**KIRKLEES METROPOLITAN COUNCIL  
INVESTMENT & REGENERATION SERVICE**

**DELEGATED DECISION TO DETERMINE PLANNING APPLICATIONS**

Reference No:	<b>2023/62/93241/W</b>
Site Address:	31, Park Hill, Bradley, Huddersfield, HD2 1QG
Description:	Erection of first floor front and side extension with dormers to front elevation, single storey rear extension of existing garage and associated alterations
Recommending Officer:	Laura Yeadon

**DECISION – REFUSED**

PROJECT	31 Park Hill Bradley Huddersfield HD21QG.		title Ground & First Floor Proposed Layout (Option 4)	
	drw.nr	PH_004	scale	1:100@A3
	date	02.01.23	account	-
	rev	-	drawn by	AS

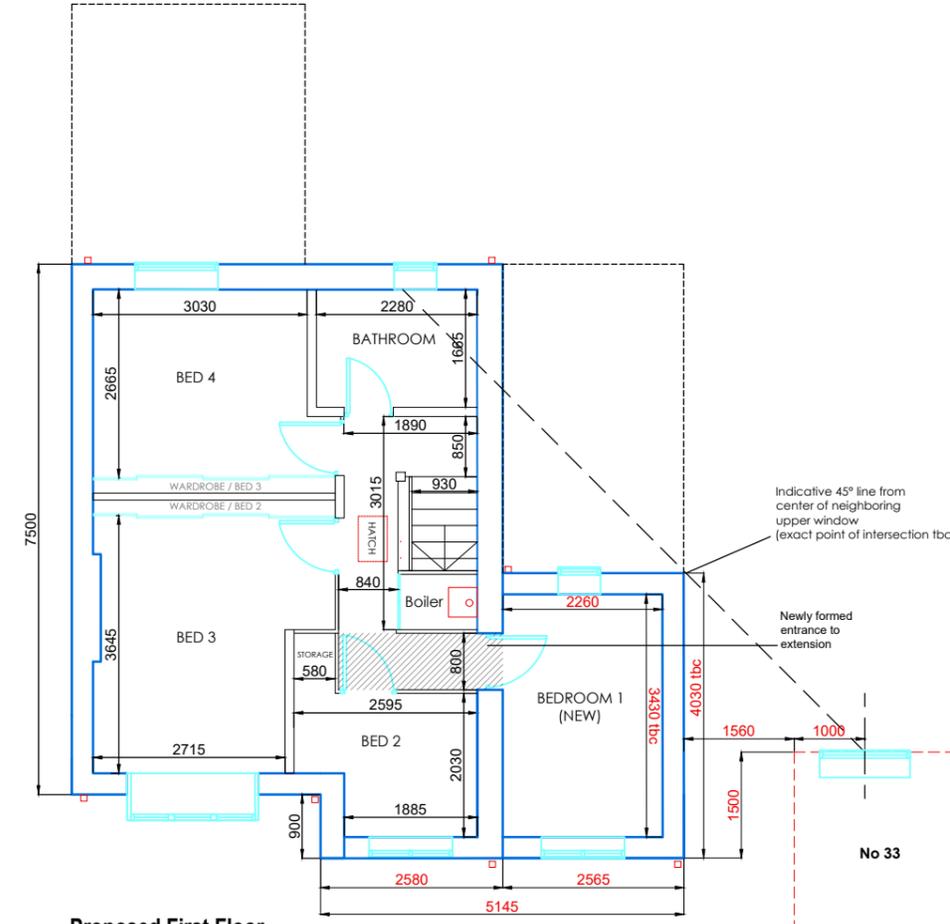
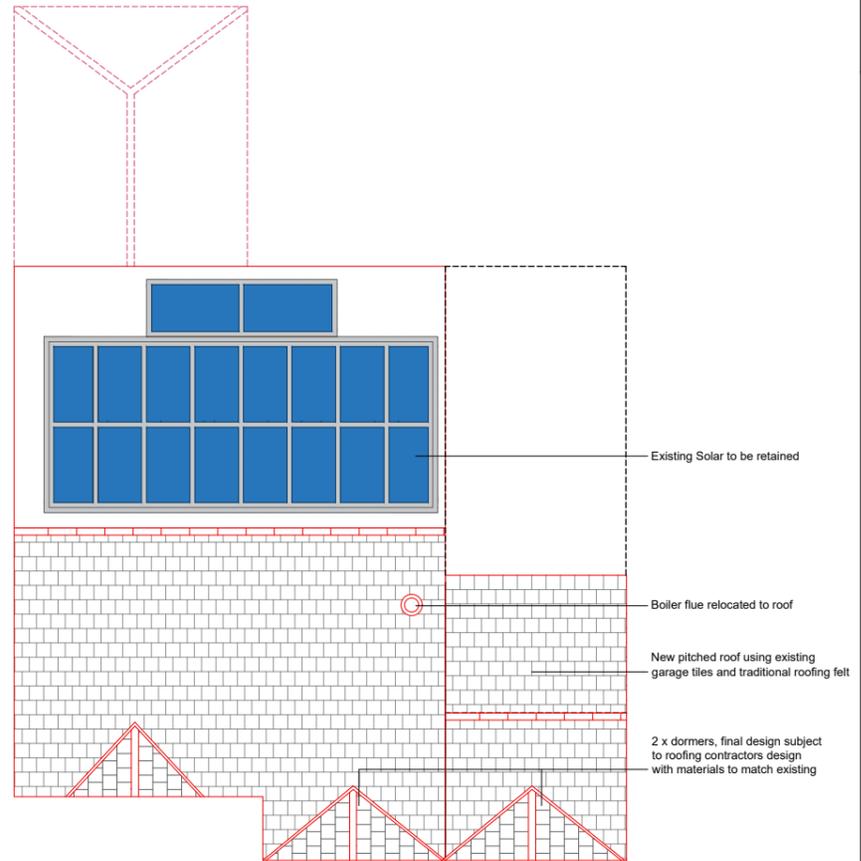
The closest property to the west of the site, where the extensions are proposed would be No. 33. This property is set significantly forward of application site and has a rear elevation which is on a similar building line to the front elevation of the application site. Due to the orientation of the dwellings, as the application site is located to the south-west of No. 33, overshadowing of this property will already occur. Whilst the side part of the extension would broadly comply with the SPD by being set in from the shared boundary, by extending above the ground floor elevations would bring the built form of development closer to this neighbour which would result in an overbearing and oppressive feature when viewed from the openings within the eastern side of the rear elevation and from the garden area of the property.

Key Design Principle 5 of the SPD recommends that the 45-degree rule should be treated as a starting point in assessing the impact for all extensions, i.e. a line drawn from the midpoint in the nearest adjacent habitable room window at an angle of 45

degrees should preferably not intersect the extension. In this instance, the amended plans submitted demonstrate a reduction in the depth of the extension to allow for the 45 degree line to be met. However, due to the orientation of the properties, the bulk of the proposed works would be closest to the rear elevation of this property which would result in a development that would be oppressive and overbearing to this neighbour.

In light of the above, the proposal is considered to have an unacceptable impact on residential amenity and would be to the detriment of the living conditions associated with No. 33 Park Hill. The scheme would therefore fail to comply with Polic LP24 (b) of the Kirklees Local Plan. Key Design Principles 3, 4, 5 and 6 of the Kirklees Local Plan.

2. The proposed extensions, by virtue of its scale, design and siting in relation to the shared boundary, would have a detrimental impact to neighbouring occupiers at 33 Park Hill forming an overly overbearing and oppressive impact to the occupiers of this dwelling. Therefore, the proposal would fail to retain a high standard of amenity for the occupiers of No. 33 Park Hill contrary to Policy LP2 & LP24(b) of the Kirklees Local Plan, Design Principles 3, 4, 5 and 6 of the Kirklees House Extensions and Alterations Supplementary Planning Document and policy within Chapter 12 of the National Planning Policy Framework.

title	Proposed Elevations (Option 4)	
drw.nr	PH_003	scale 1:100@A3
date	02.01.23	account -
rev	-	drawn by AS

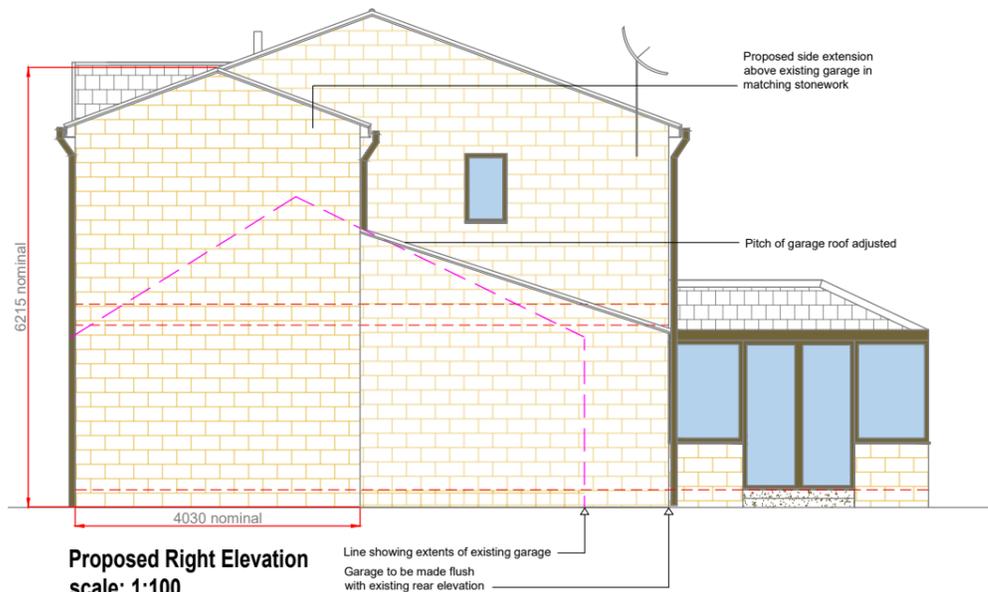
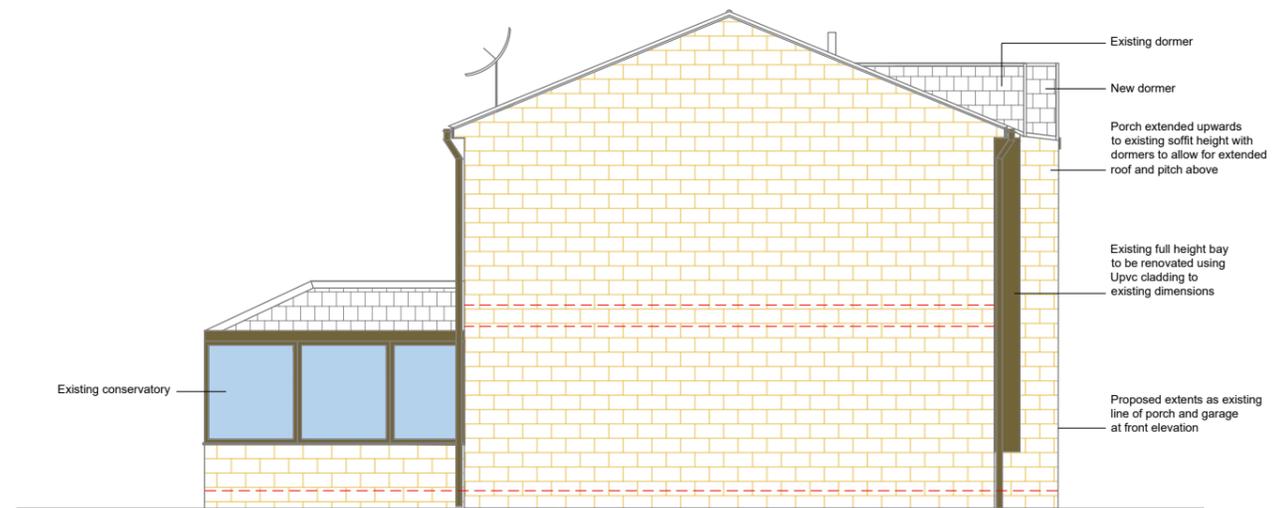
In this case, it is proposed that a first floor extension would be located on the front and side of the property, above the existing porch and the existing garage spanning a 4 metre depth down the side of the property in a wrap around style. The eaves height would match the existing with dormer features installed and the roof line of the extension would be set down from the existing.

Whilst the scheme has been reduced in terms of volume with the roof line being set down and the depth of the side extension being reduced, due to the increase in bulk to the front of the property, it is not considered that the works would be subservient to the host property and would therefore be contrary to Key Design Principle 2 of the SPD.

In terms of the front section of the extension and its compliance with the SPD, it is noted that the application site is set back from the roadside however it is not screened, the proposed construction materials would match the host property. However, it is not considered that the extension would be small or subservient to the host building and would introduce a triple pitched roof feature which is out of character with the host and surrounding properties. It is noted that the design of the properties within the street scene have a single pitched feature as the application site does currently and some properties have a larger gable feature to the front however, the introduction of additional features and would result in a design which would appear cramped and incongruous within the street scene, contrary to the SPD.

With regards to the first floor side element of the proposal and with specific regard to visual amenity, the extension would be set above the existing side elevation of the garage, spanning a depth of 4 metres. In terms of the SPD, the extension would retain a gap of 1 metre to the side boundary however is not set back from the front of the property due to the proposed first floor front extension. Therefore, the proposed side extension would not comply with the requirements of the SPD.

The proposed single storey rear extension would be located behind the existing garage with a side elevation lying flush with the existing garage and a rear elevation lying flush with the rear elevation of the property. Due to its siting to the rear of the property, it is not considered that this element of the scheme would be particularly harmful to visual amenity as it would be afforded little views from public vantage points. The extension would retain a gap to the boundary, would not project more than 4 metres and would not and would not exceed 4 metres in height.

Taking into account all the above, it is considered that the proposal would not be a subservient addition to the host property and by virtue of its location, design, scale and massing, would cause detrimental harm to the host property and wider locality. The proposal is therefore not considered to comply with the policies within Chapter 12 of the NPPF, LP24 of the Kirklees Local Plan or Key Design Principles 1 and 2 of the House Extensions and Alterations SPD.

1. The proposed extensions by virtue of their design, scale and massing would not be of a subservient addition to the dwelling and would appear as an incongruous and discordant addition to the host dwelling, which would, in turn, harm the character and appearance of the dwelling and the wider street scene. The proposal is therefore contrary to Policy LP2 & LP24 (a) and (c) of the Kirklees Local Plan, Key Design Principles 1 and 2 of the Kirklees House Extensions and Alterations Supplementary Planning Document and Policy set out in Chapter 12 of the National Planning Policy Framework.
